From: Richard Castro-Parker
Sent: 23 September 2019 12:58
To: Daniel Vick
Subject: FW: BE/139/18/PL - Innovation Centre Beeding Close

From: Richard Castro-Parker
Sent: 23 September 2019 12:19
To: Laura Gibbons <Laura.Gibbons@arun.gov.uk>
Cc: Juan Baeza <Juan.Baeza@arun.gov.uk>; Samantha Lee [REDACTED]
Subject: FW: BE/139/18/PL - Innovation Centre Beeding Close

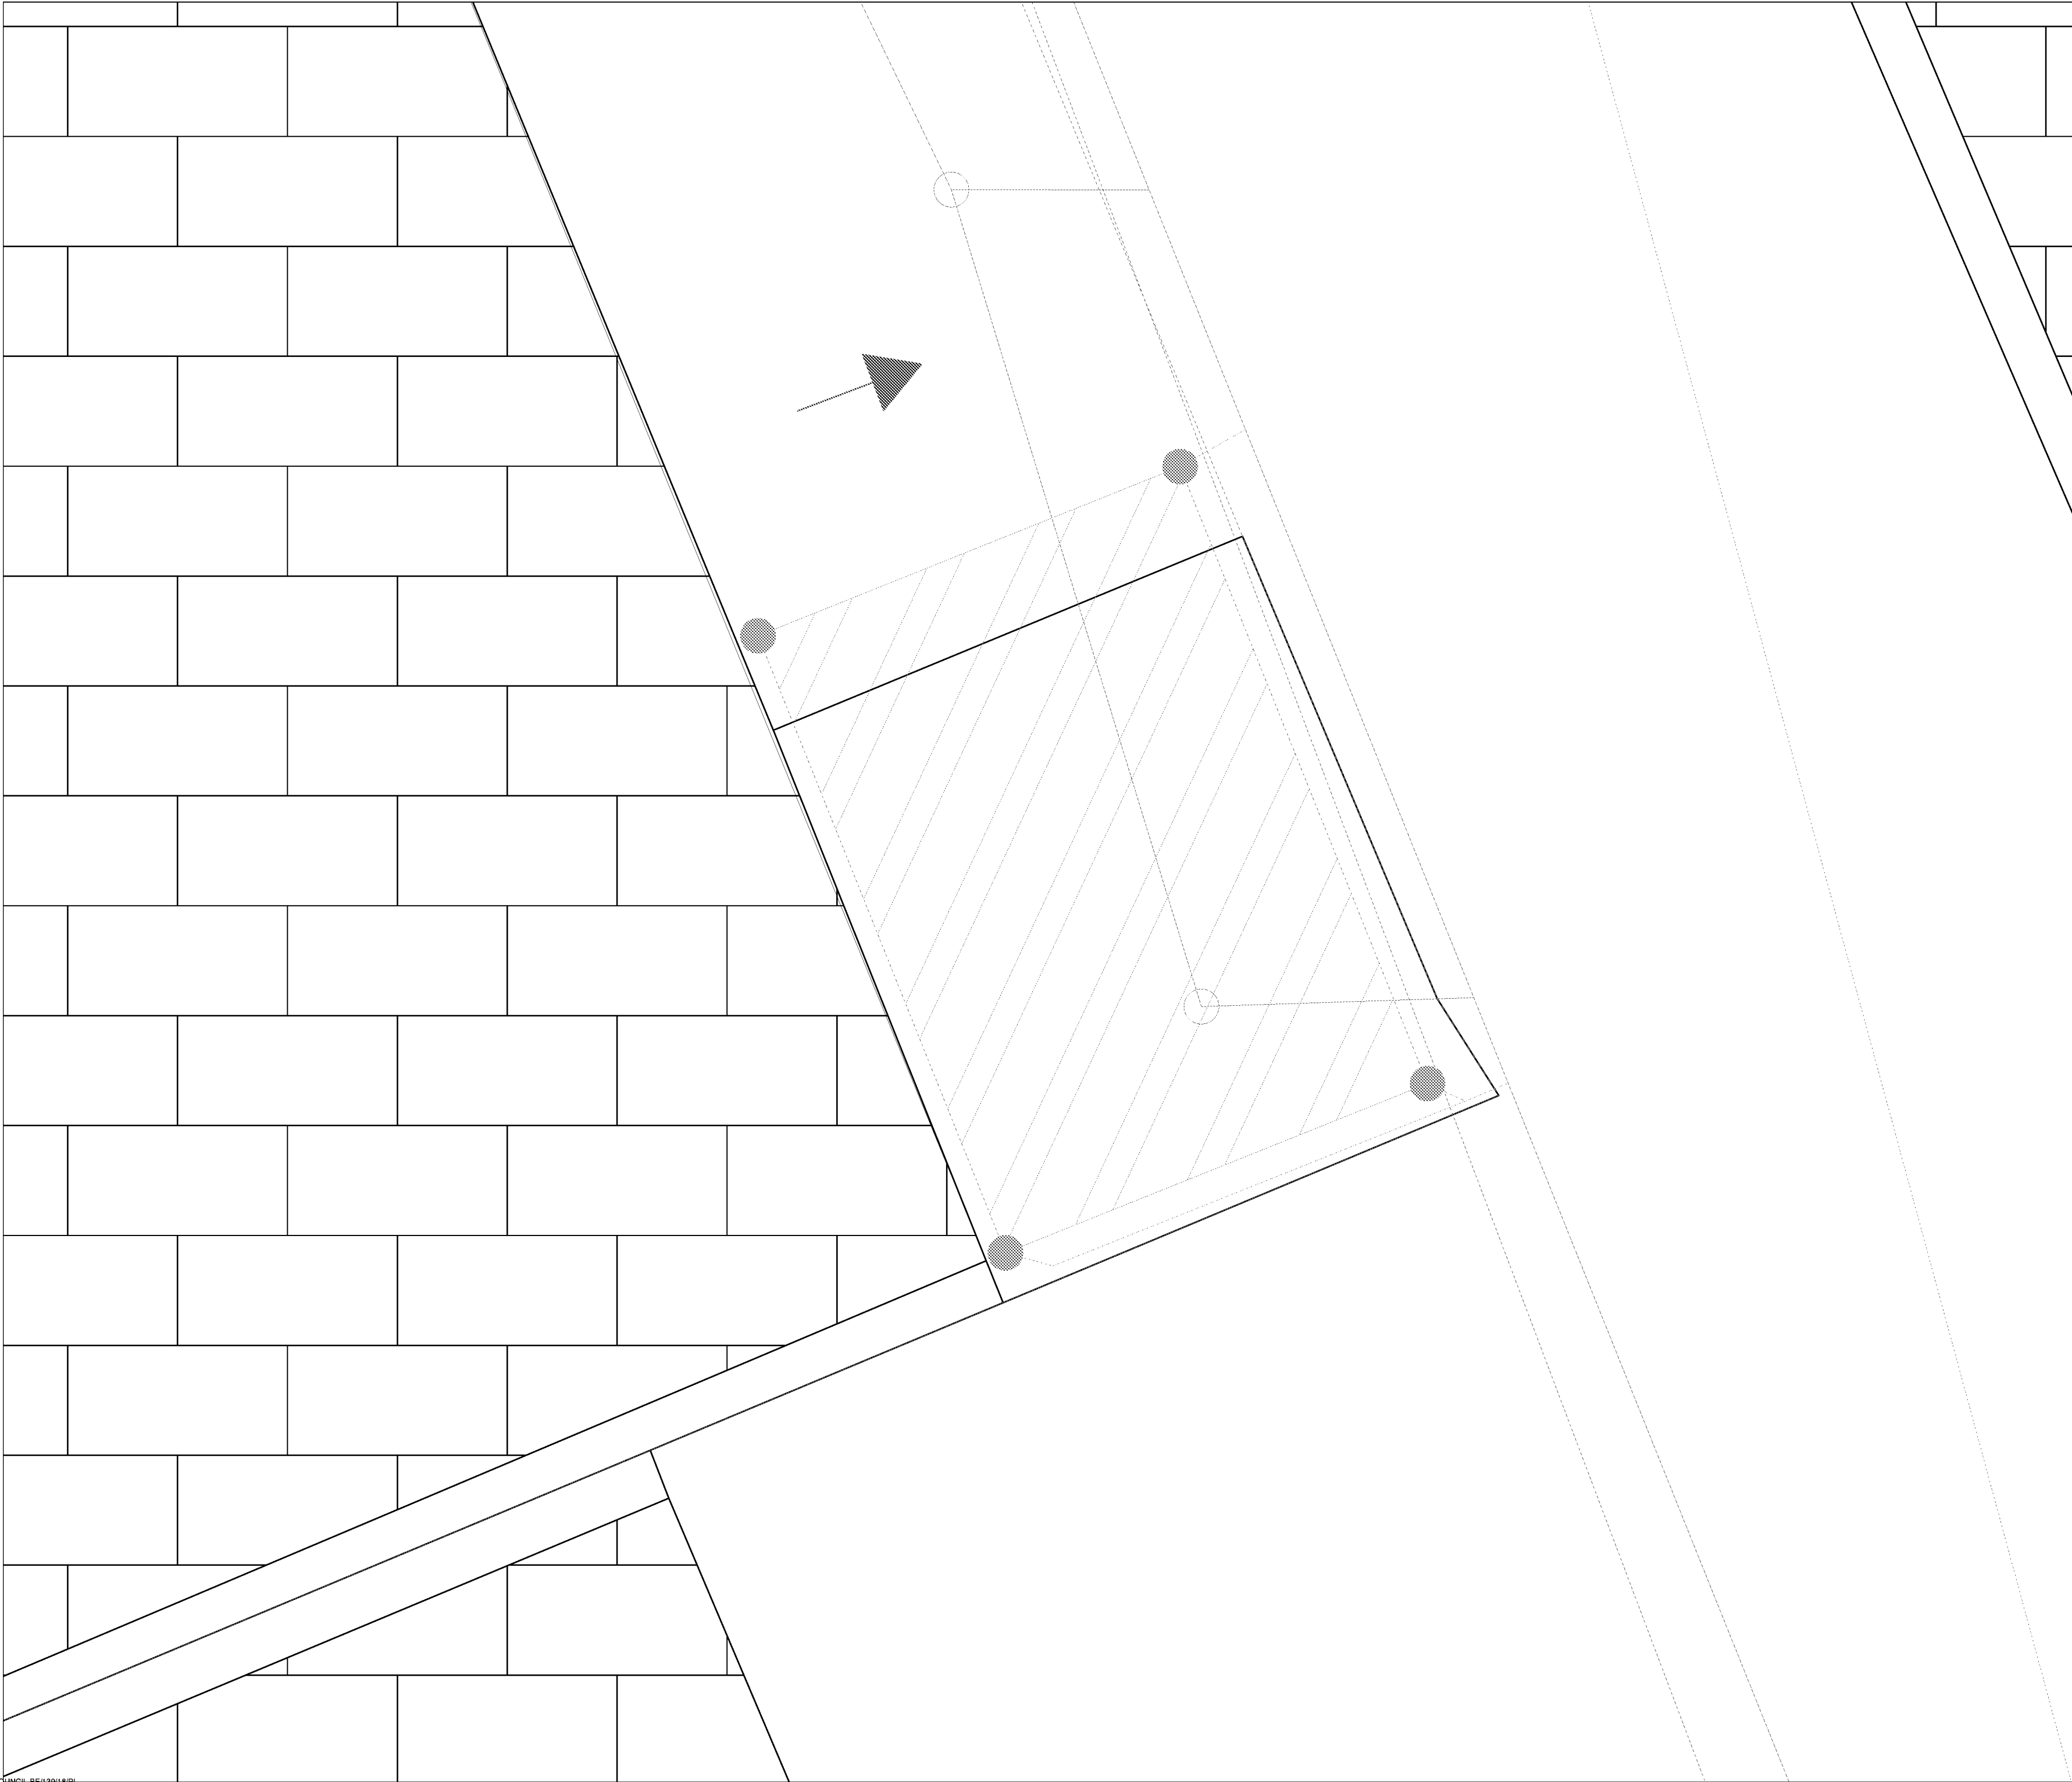
I still am struggling to distinguish between lines. Please can different line types be used, rather than all very similar colours. Please can gullies, manholes, and linear drainage channels be clearly labelled.

The colour of the lines have been changed and it is very different from each other in my screen. Please therefore let me know if Laura is still unable to distinguish them. I've also got confirmation from the client that they already have someone booked in to have the drainage cleaned.
